Application no: H11-0665-10

Description: Joinery details (Condition 5 of H11-0398-10)

Location: 6 Market Street
Long Sutton
Spalding
Lincs
PE12 9DF
PE12 9DF

Amendment: Amendment to show 2 glazed panels to top of
replacement door (dwg. no. 2133/05.A)

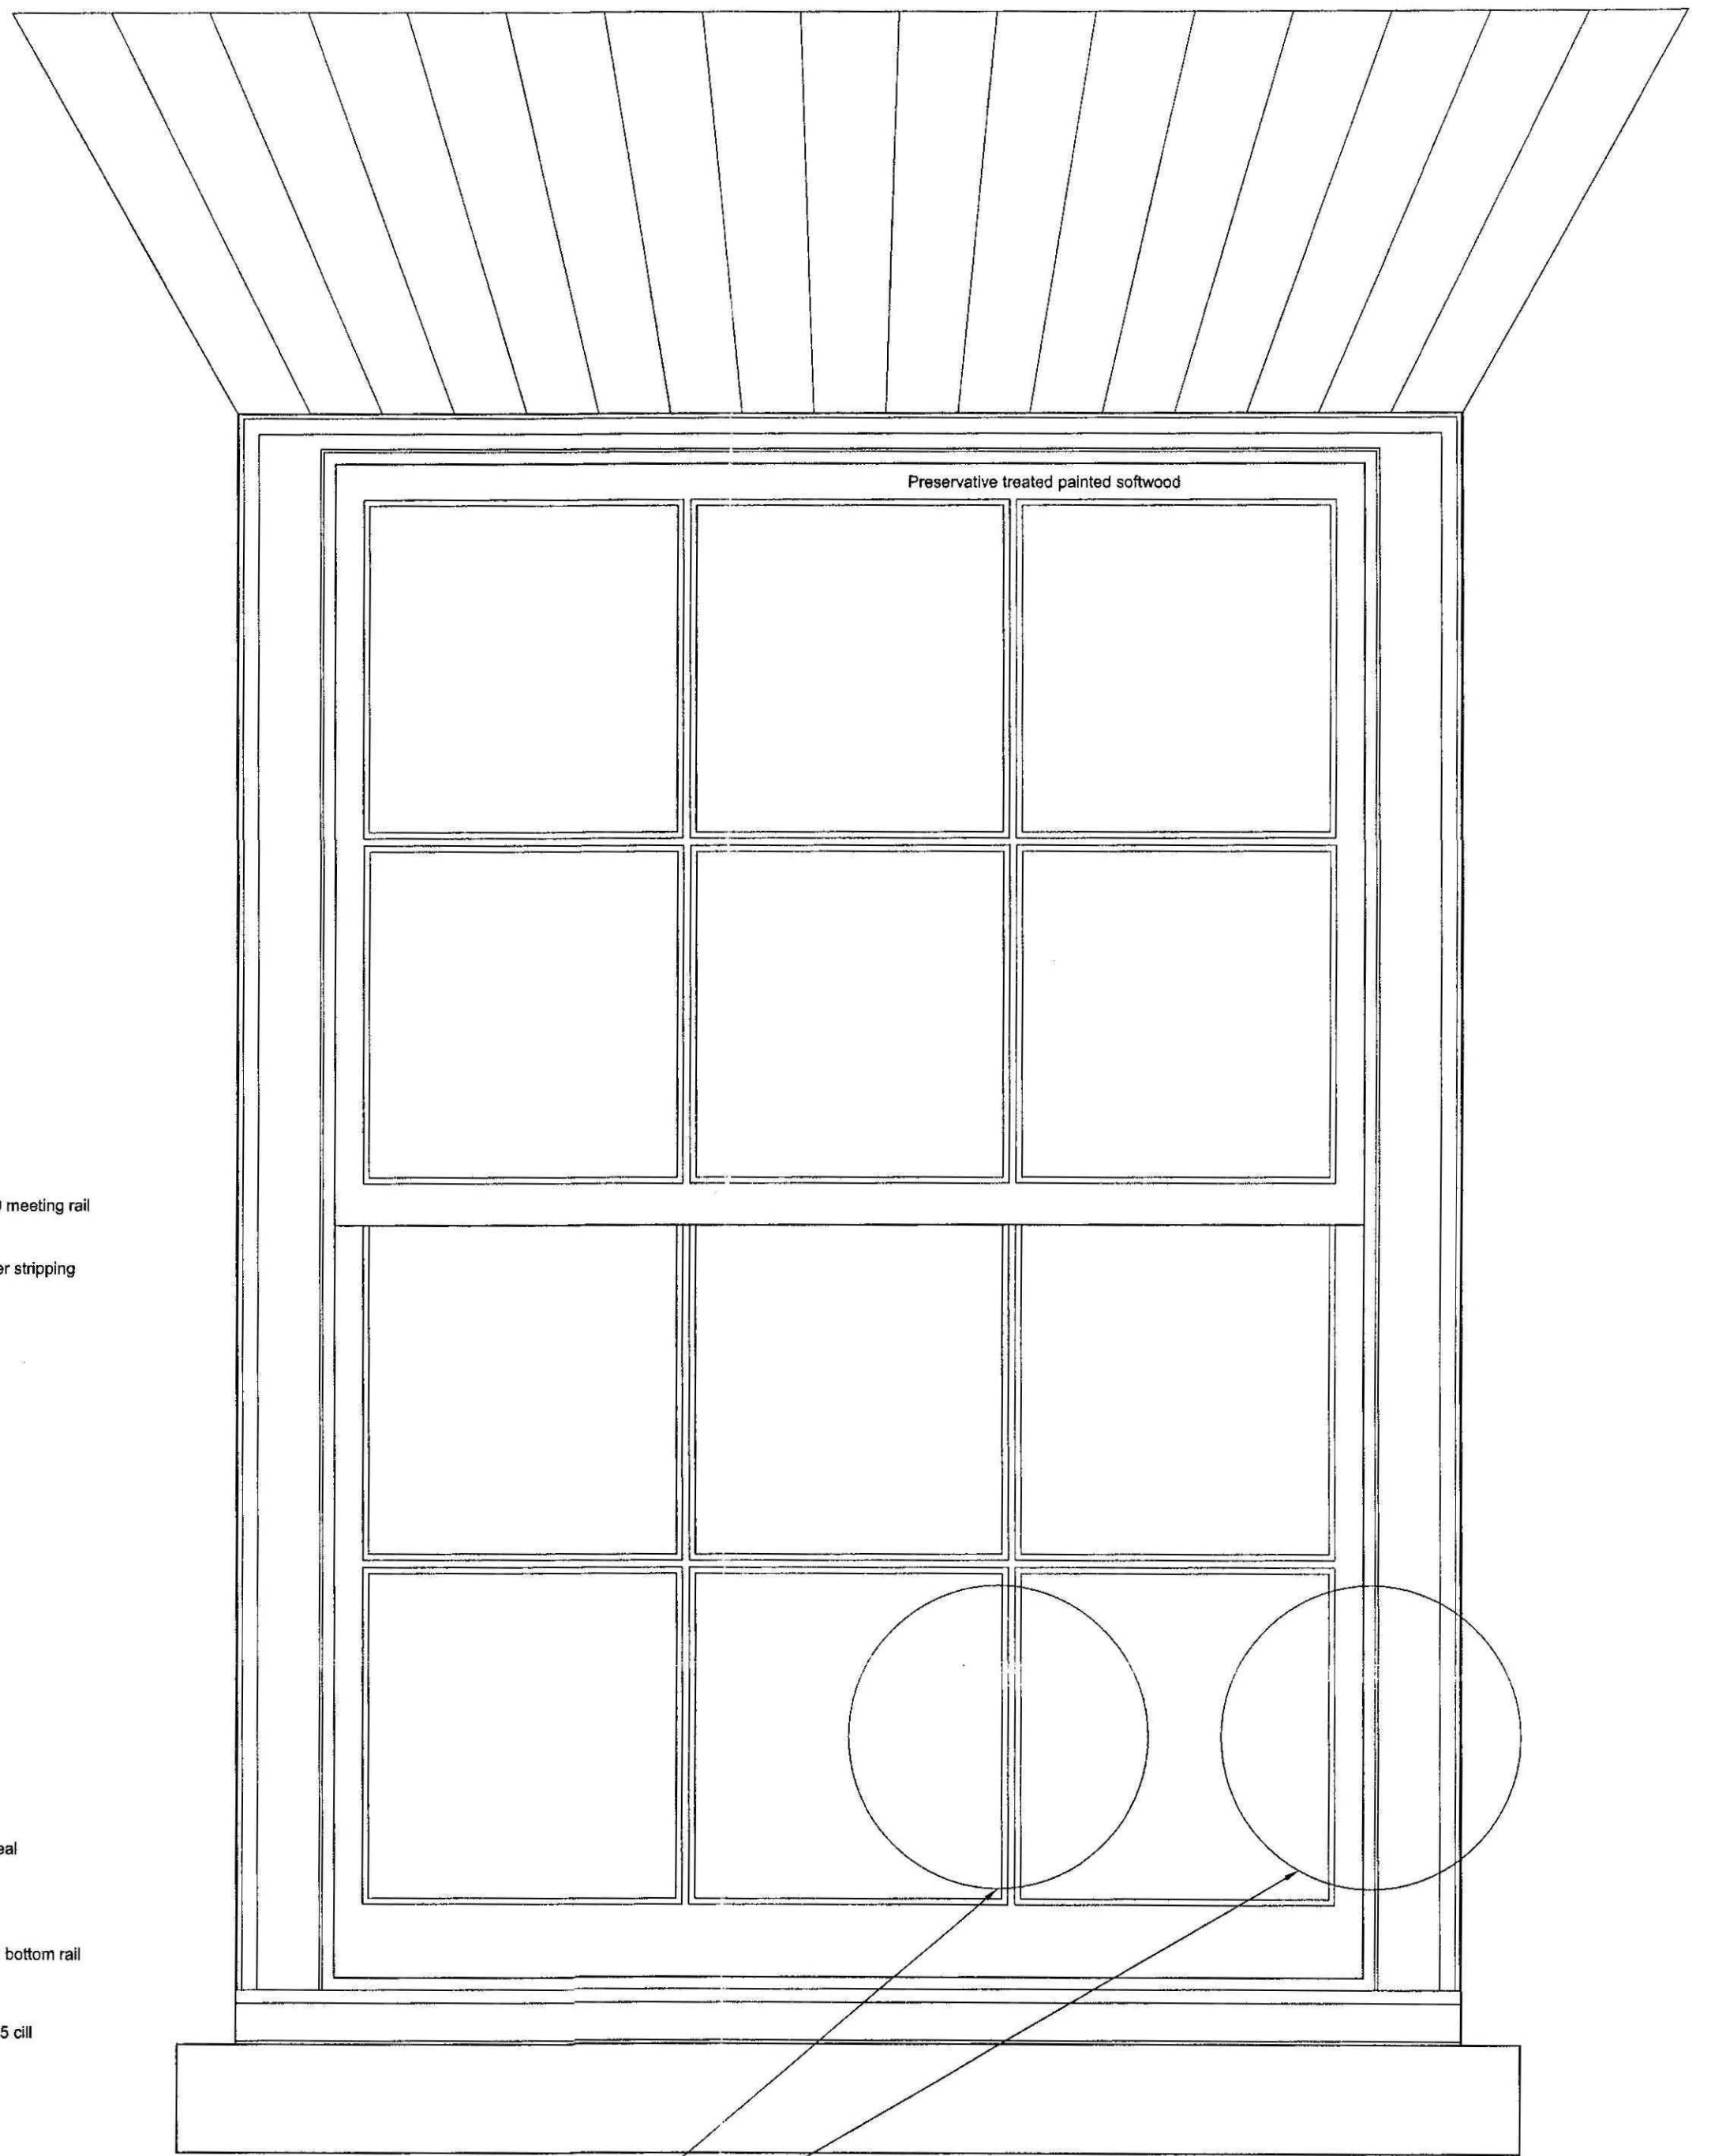
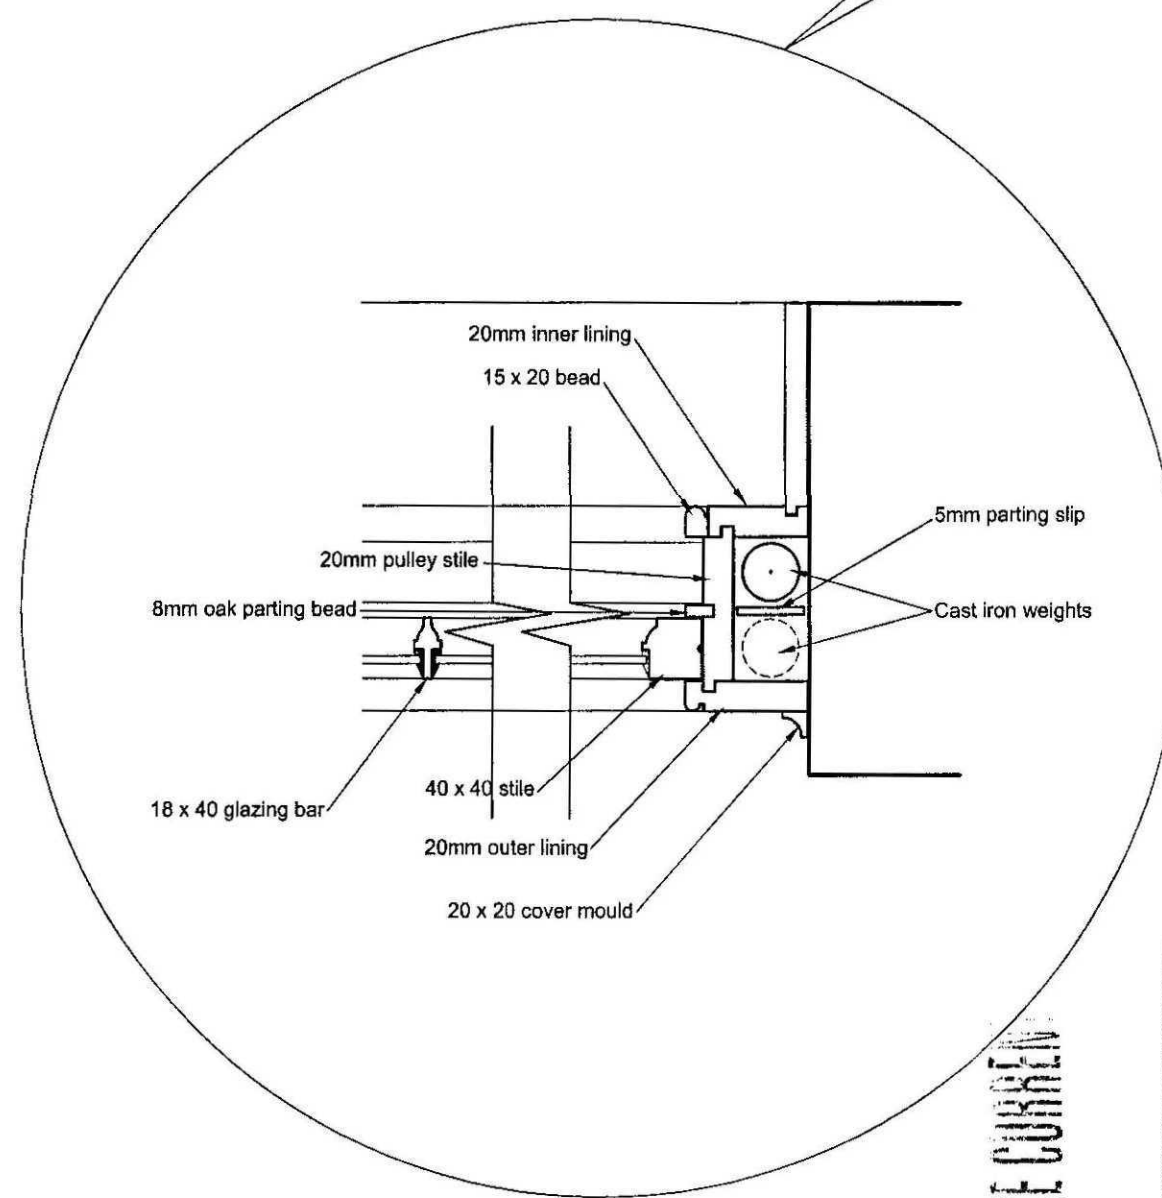
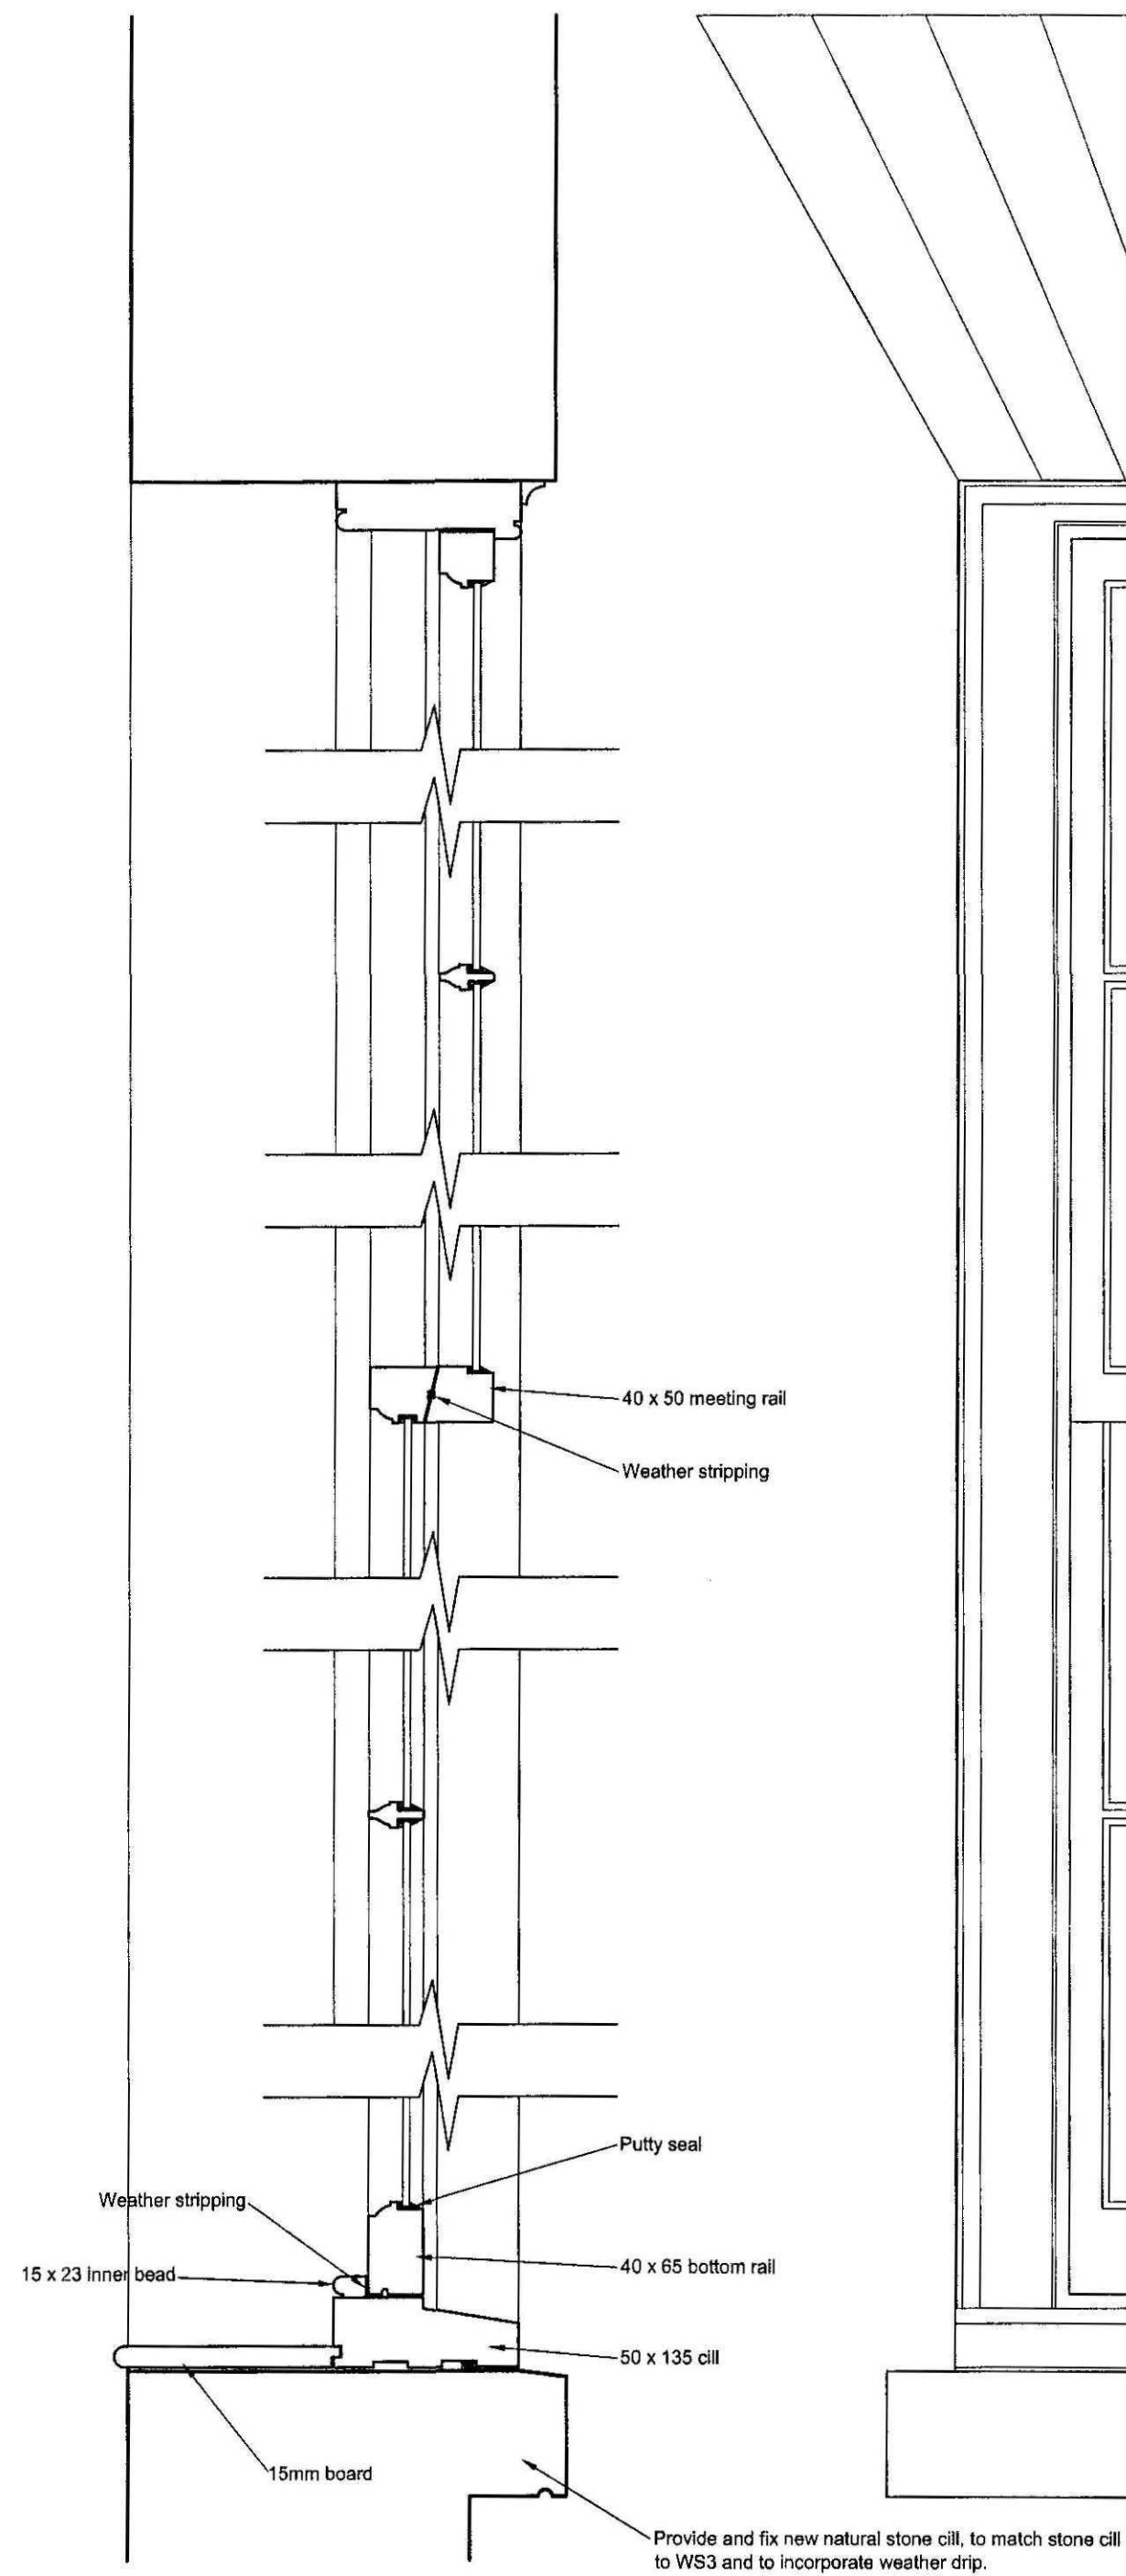
Further to the writer's telephone conversation with Mrs Middleditch on 6th September 2010 we enclose one copy of our Drawing No. 2133/05A indicating 2 no. glazed panels to the top of the replacement door (DG3) and note that this amendment is acceptable to you.
